A. A. Takla Engineering, PLLC

Project: 224 Sneed Ln.
Location: Fuquay Varina, NC
Company: Gutierrez Framing
Care Of: Alex Mejias
Subject: Framing Items
Job Number: 1582-23

As requested, Andy Takla, PE visited the above referenced site on October 3rd, 2023 to review the following framing items presented to engineer by the framing contractor:

1ST FLOOR FRAMING PLAN
ELEVATION A
WALLS AND CEILING
1/8" = 1'-0"

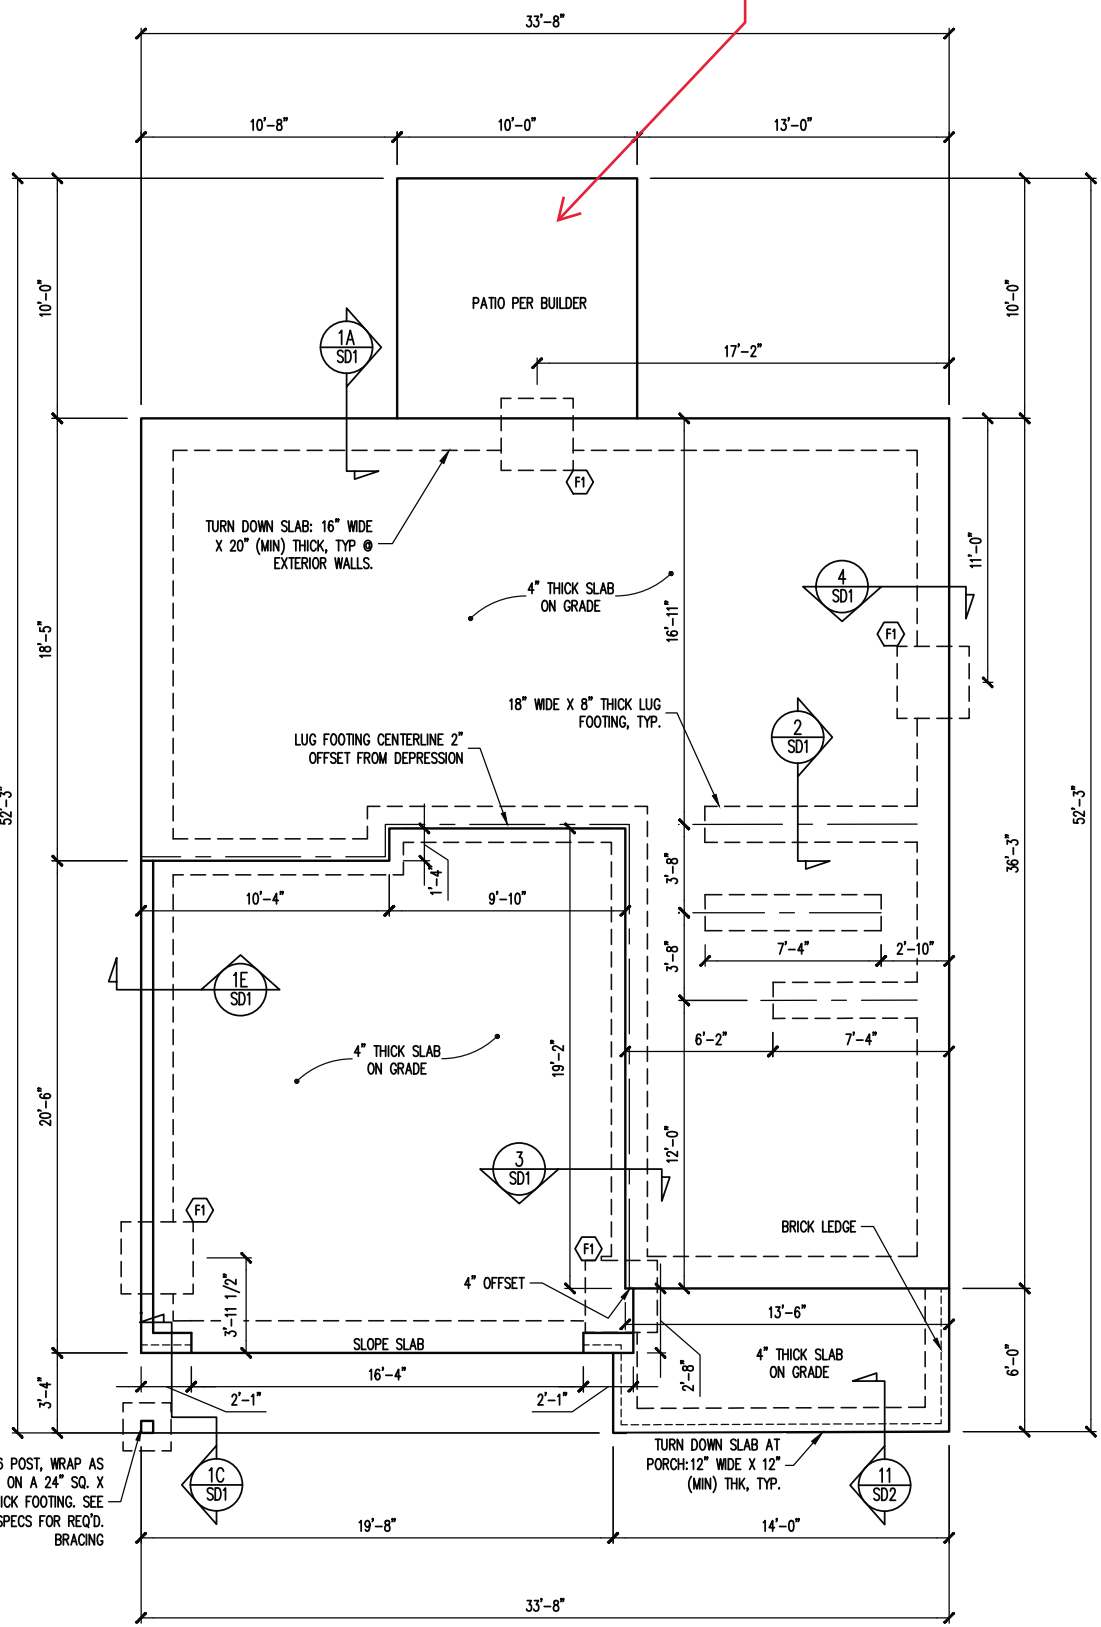
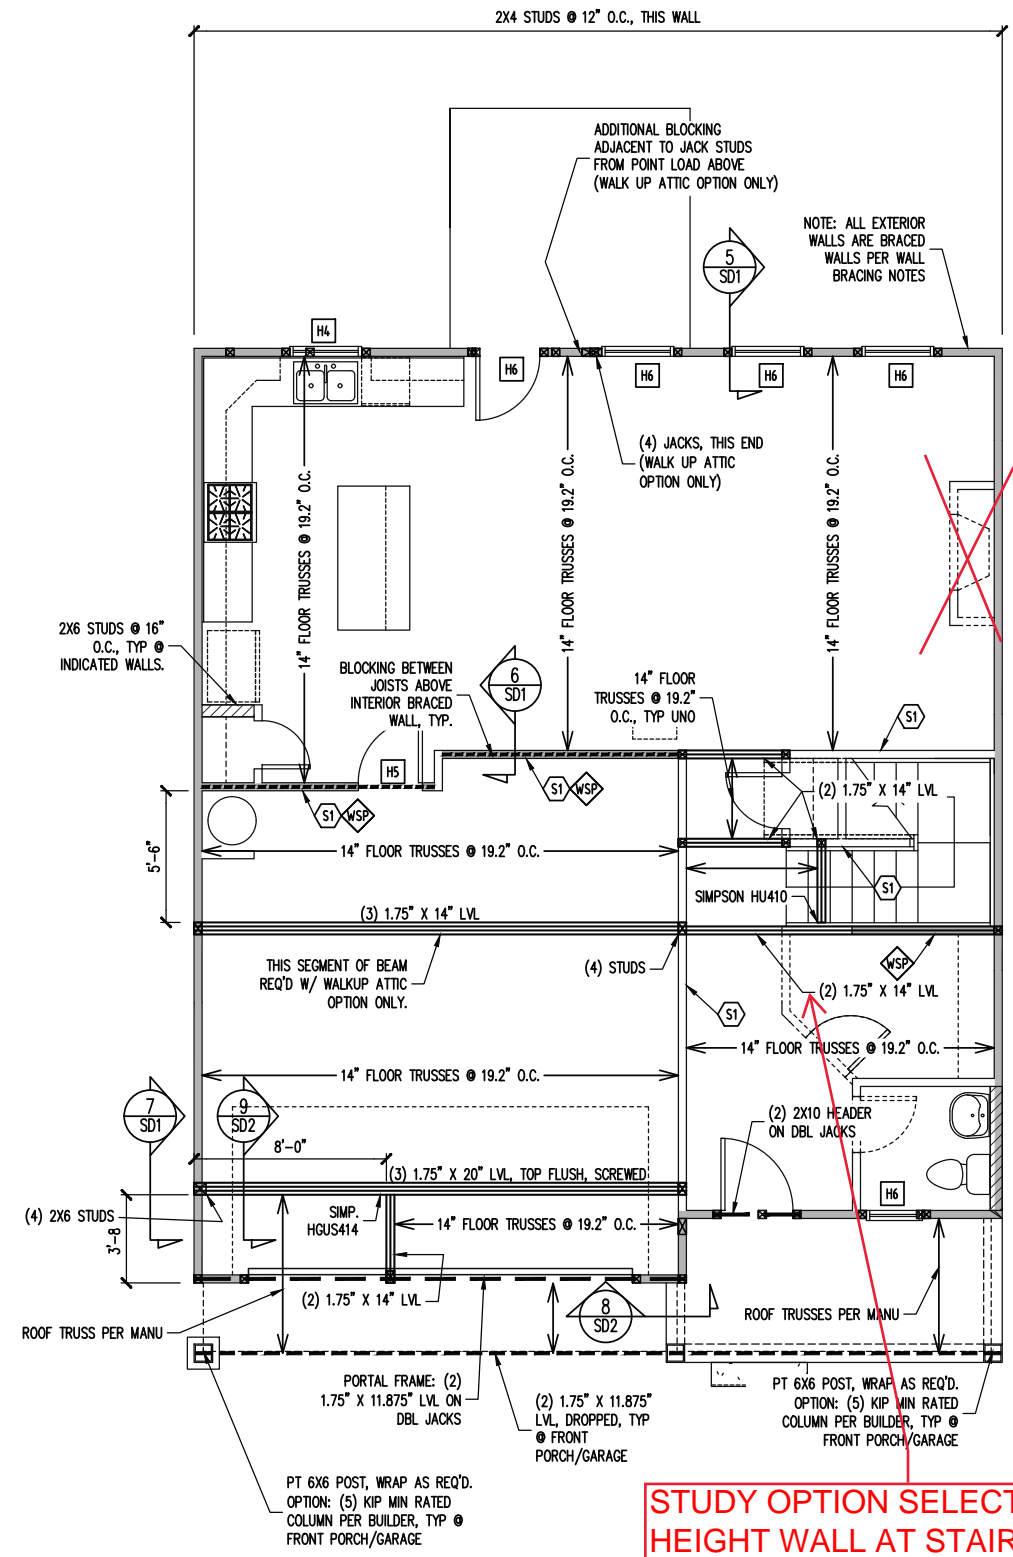
- 2) The per plans (2)14" LVL in-line with the forward stairwell wall (in 1st story ceiling) does not extend to the right exterior wall as specified in the plans; Instead it stops at the right foyer wall (unfortunately where no lug footing exists). Based on review **we recommend removing the OSB sheathing attached to the front face of the front stairwell wall, cutting the bottom 14" of all studs in this wall (including the stud column which support the right end of the (2) 14" LVL beam), and install a (2) 14" LVL beam extending from the right exterior wall to the aforementioned stud column. Allow beam to continuously bear on the bottom plate. It is acceptable to notch the beam as required about any anchor bolts. Thereafter, reapply sheathing. This repair is intended to support the point load via the (2) 14" LVL "in cantilever" as to not apply significant loading on the location of the slab lacking the lug footing.**

2ND FLOOR FRAMING PLAN
WALK UP ATTIC OPTION
ELEVATION A
WALLS AND CEILING
1/8" = 1'-0"

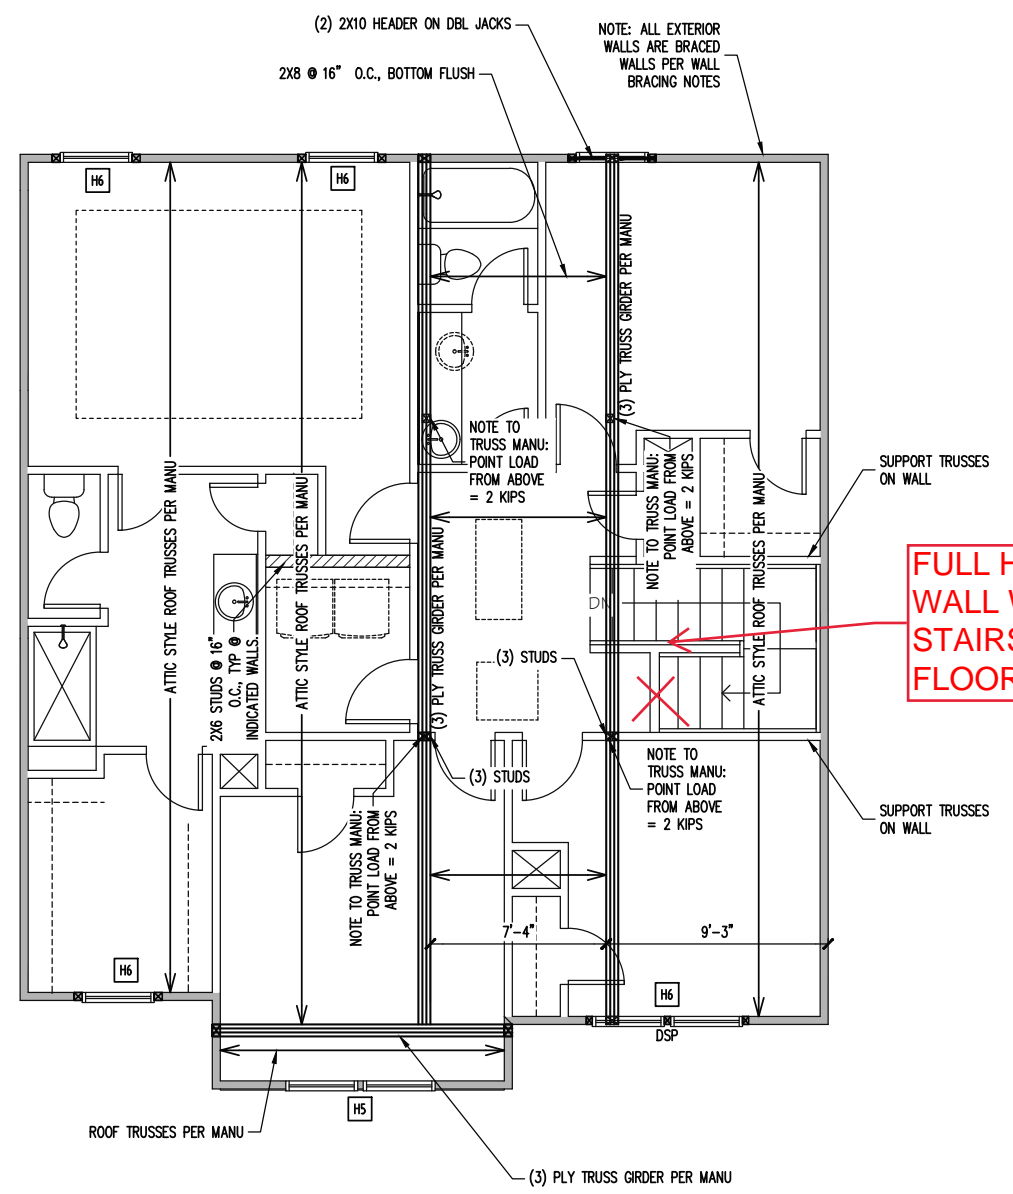
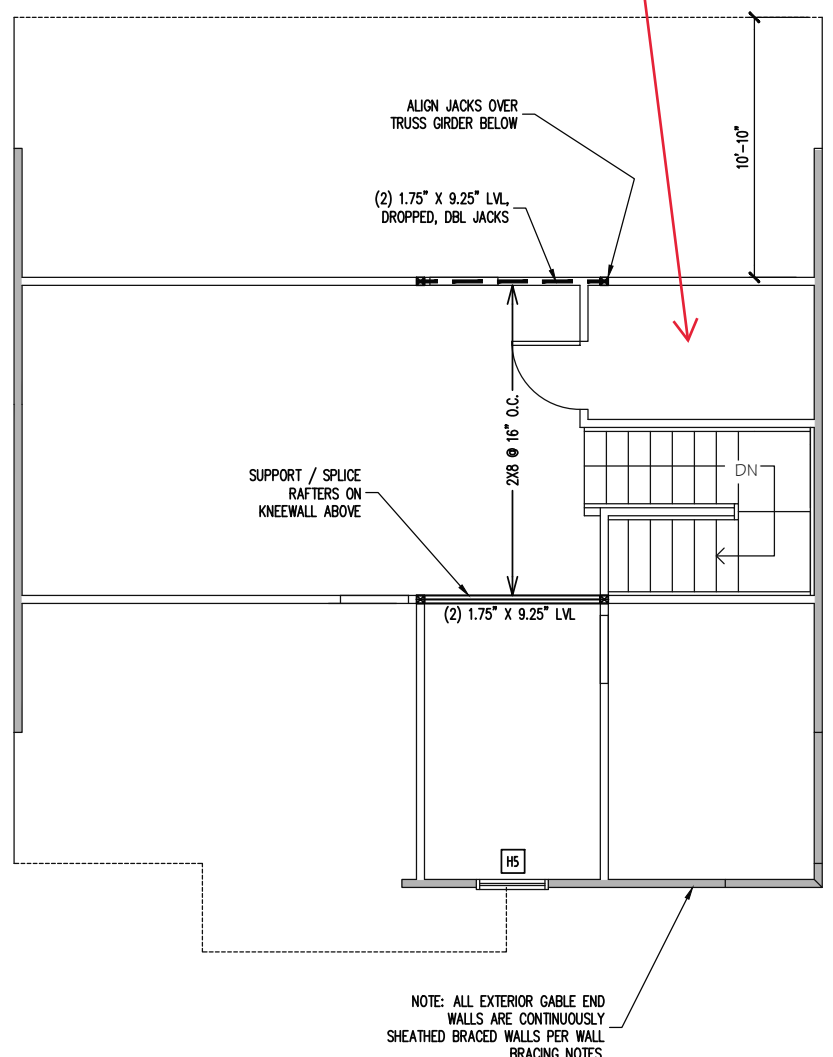
- 3) The framing overhead as one enters the 2nd story (near top of stairs) is framed very differently from the sealed plans. This is primarily a result of an error when designing the right side 3 ply girder roof truss. The girder truss's bottom chord was cut at the stairwell wall to accommodate adequate head room. We understand the framers have implemented changes to this area (to include the installation of three (3) 9 1/4" flush LVL headers to transfer loads to 2nd story walls) as instructed by the truss suppliers. Based on review, the framing is found to be both appropriate and adequate to carry the loads **provided a (4) stud column is installed supporting the right end of the rear (left-right) spanning (2) 9 1/4" LVL at the rear stairwell wall; Install the same (4)2x4 stud column in the 2nd story wall, and 1st story wall to the foundation. No additional foundational reinforcements are required.**

- 4) At least four (4) 2x10 bottom chords of roof trusses to the right of the right side 3 ply girder roof truss at bearings on rear stairwell wall (of 2nd story) are less than adequately bearing on the wall. **Moving forward, we recommend installing a 4' long 2x10 scab to one side of each bottom chord; Allow scab to fully bear on top plate and attach with (3) 10d nails spaced at 6" on center.**

ROOF FRAMING PLAN
WALK UP ATTIC OPTION
ELEVATION A

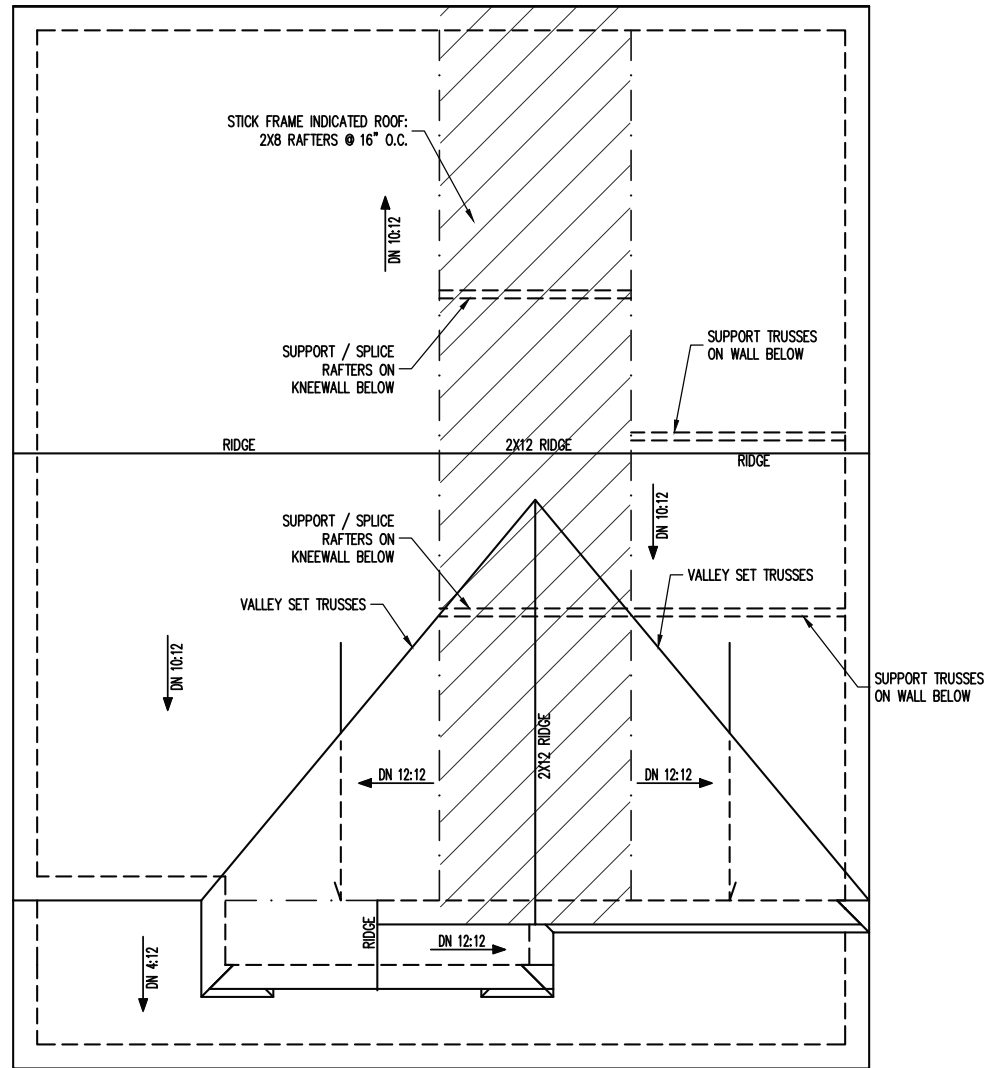
- 5) In the 3rd story, several rafters (where bearing on a (4)stack 2x4 top plate) are excessively notched. **Moving forward, we recommend installing an L50 clip to at least one side of each rafter; Connecting the lower portion of the rafters to the (4)stack top plate. Typical at each.**
